Response to Planning Application

Application ref: BN/38/21/PL

Description: Construction of feature entrance wall set back from access to approved residential development.

Location: Land At Angels Nursery Yaptan Road Barnham PO22 0AY

| Drawing Number |    | <b>783-DET-002</b>                |            |

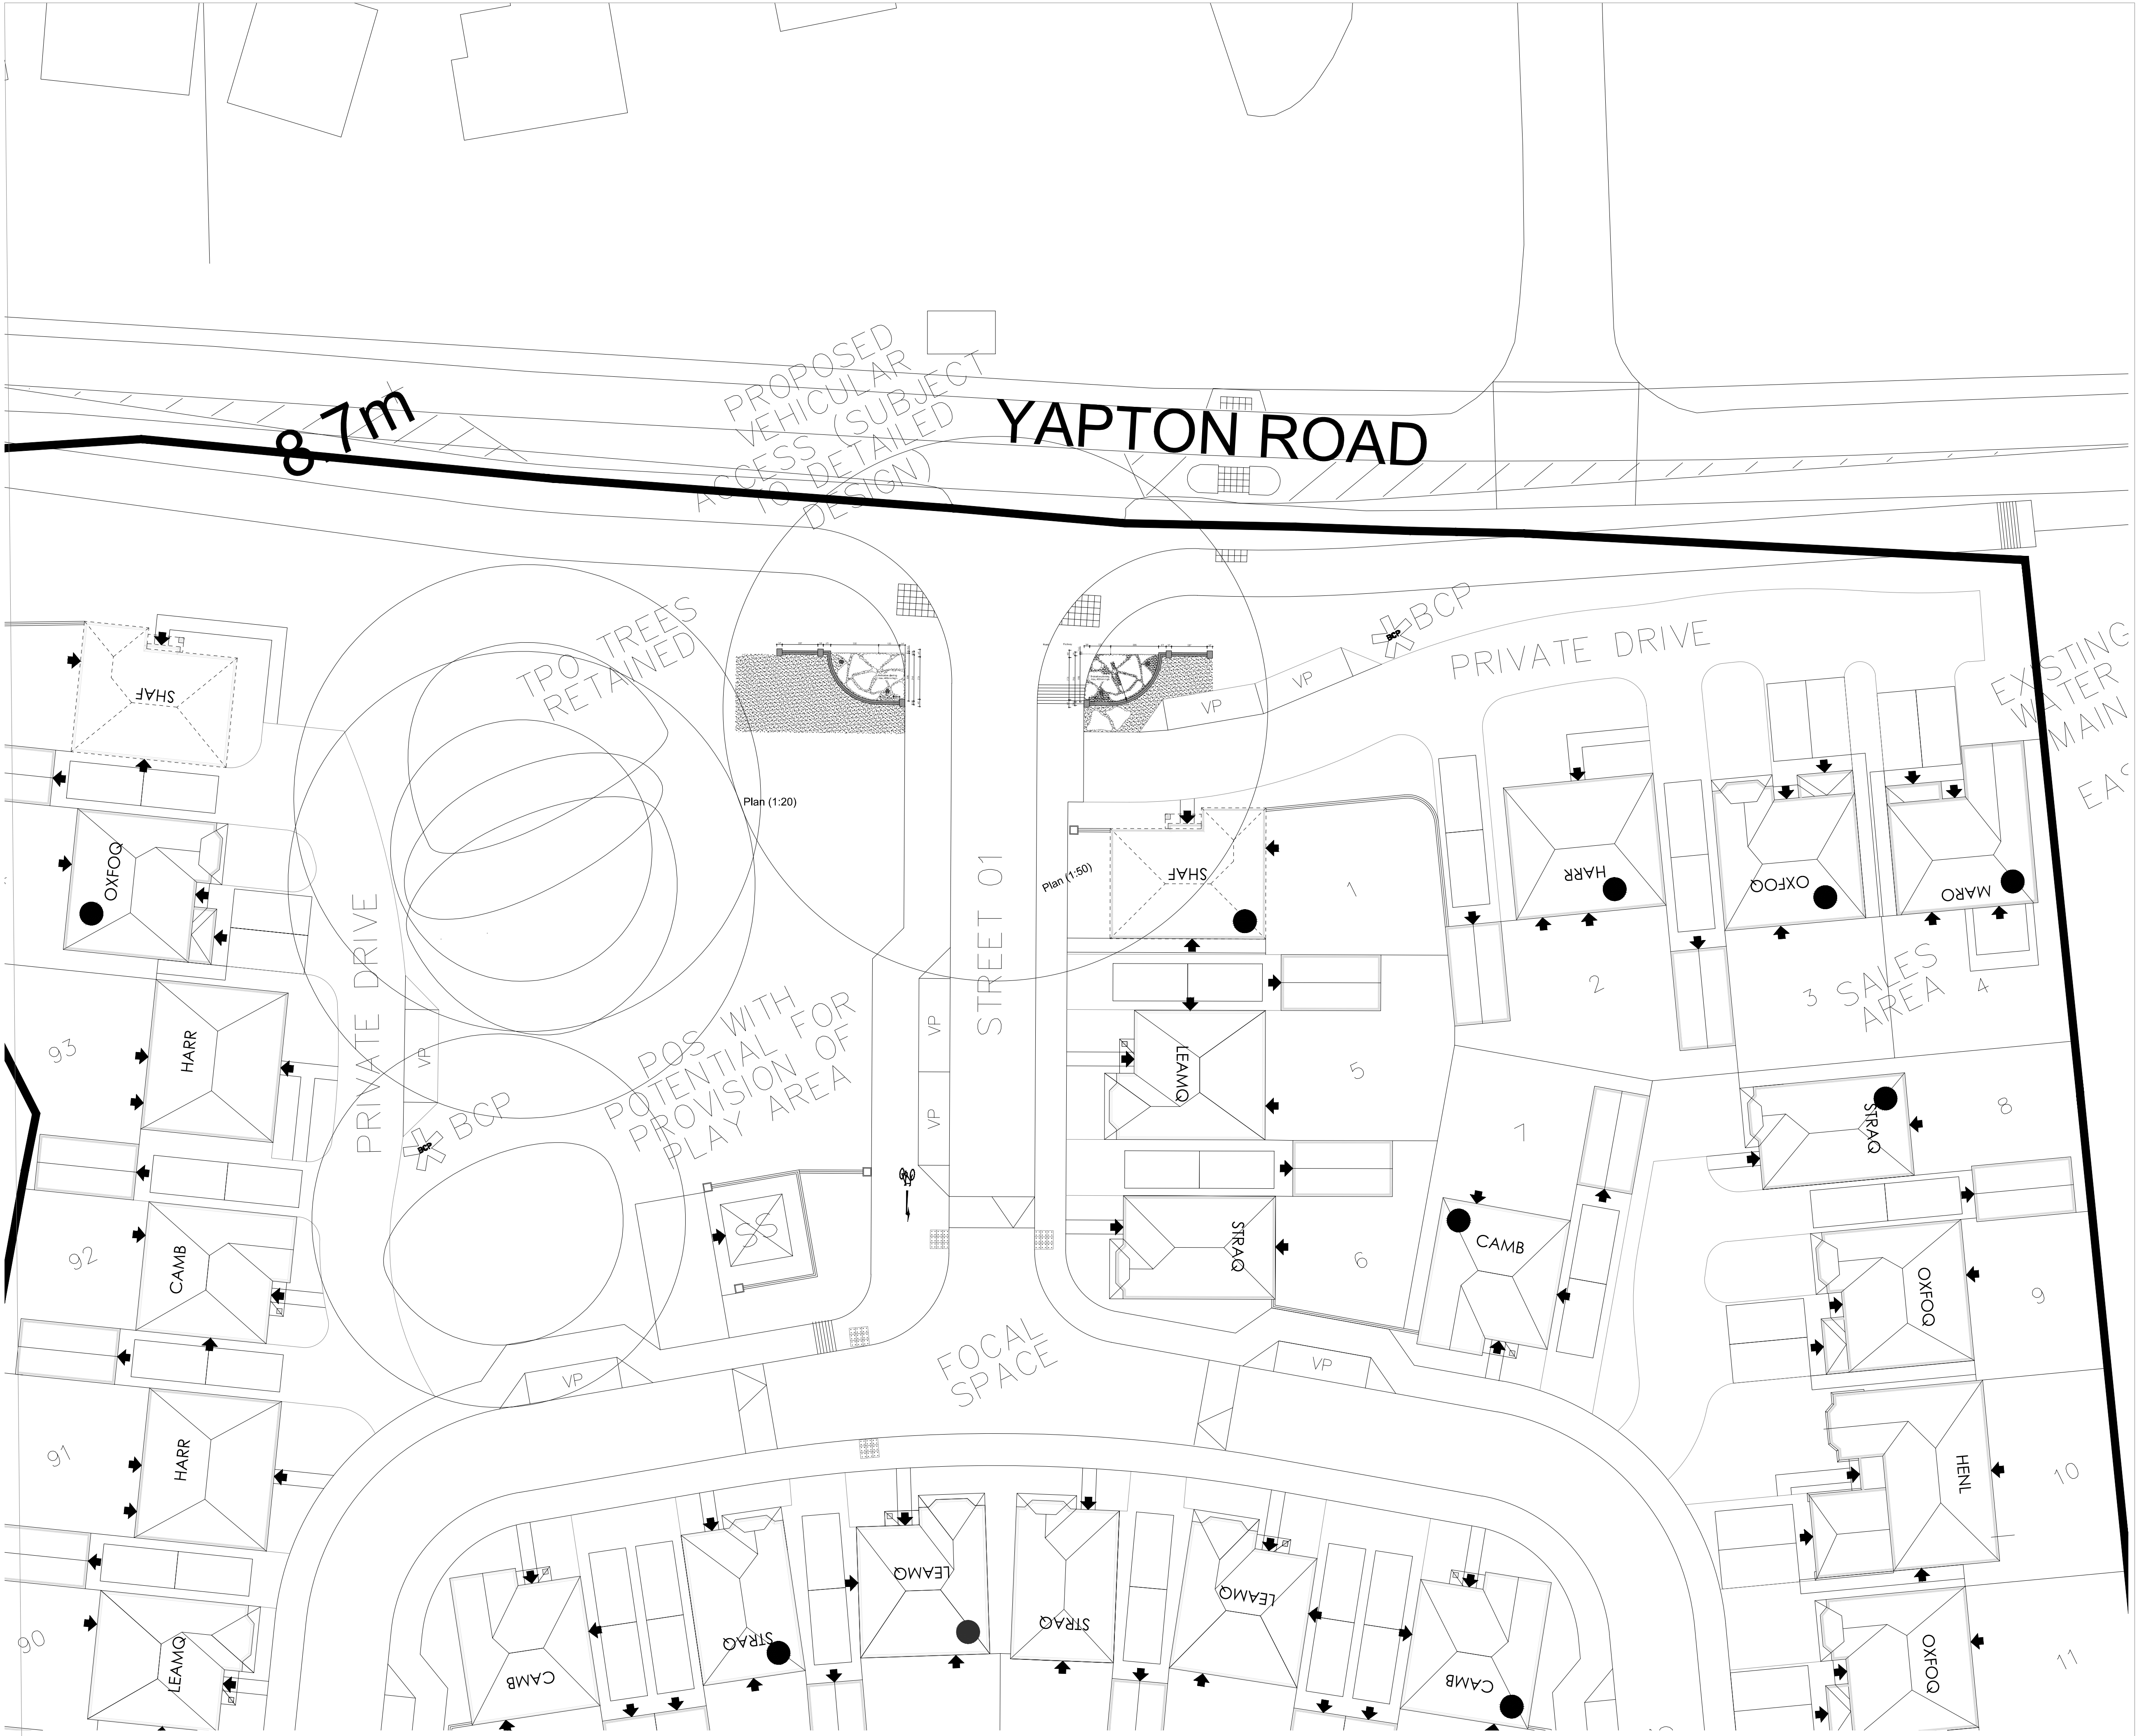
The Site Entrance Feature Wall Dwg 783-DET-001 has shown indicative planting to enhance this entrance feature which if correctly planted and maintained will soften the look of walling in this semi-rural location. That said the planting choice for this location would be assumed to be ornamental rather than native in species choice.

The indicative planting will need to be detailed in plan form to show quantities, species choice planting densities and size at time of planting. The planting will need to be selected to form a scheme which will be appropriate for setting and will establish and mature over time if it is to remain as a fixed feature in this location (rather than temporary sales arena planting)
